FIRE PREVENTION BUREAU

14 September 2017

RE: CBL 061 C018001

Thanhauser, Eliah P
315 Spring St. Rear
Portland, Maine 04102

**FIGURE 4.2(a) Chimney or Vent Termination Less Than 10 ft (3.1 m) from Ridge, Wall, or Parapet.**

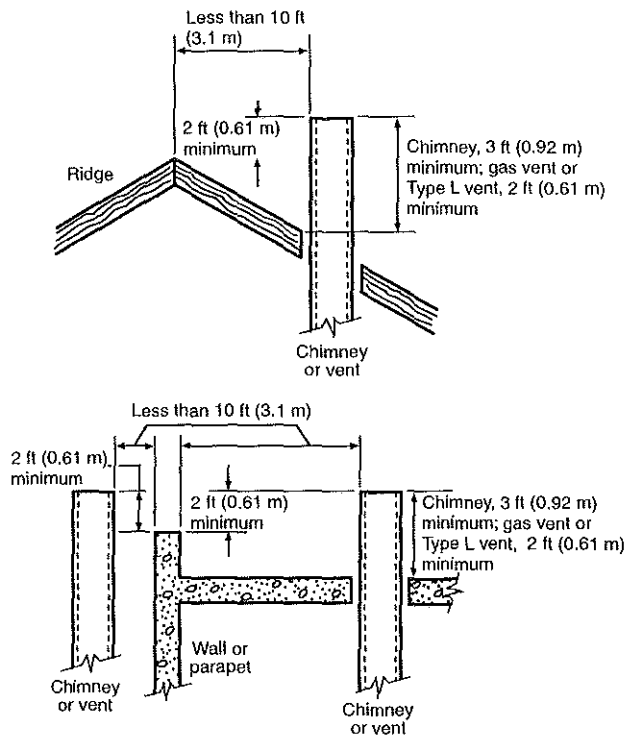
Under NFPA 211 The Standard for CHINEYS, FIREPLACES, VENTS, AND SOLID FUEL-BURNING APPLIANCES Sec. 4.2 Termination (Height). The standard states in 4.2.1 *Masonry chimneys shall extend above the highest point at which they pass through the roof of a building by at least the distance specified in Table 7.2, Column VI, and shall also extend at least the specified distance above any portion of any structure within the specified proximity (measured horizontally from the vertical chimney line) in Table 7.2, Column VII.*

The distance listed in the table is 2 feet above for the highest point for a building that is within 10 feet to nearby structures. The rear chimney at your property does not have the distance to the property located at 92 Emery St.. This can be found on page 22 of NFPA 211, you may refer to this standard at NFPA.org

Please discontinue all use of this chimney and fireplace or fuel-fired appliance until corrections are made to meet compliance with codes.
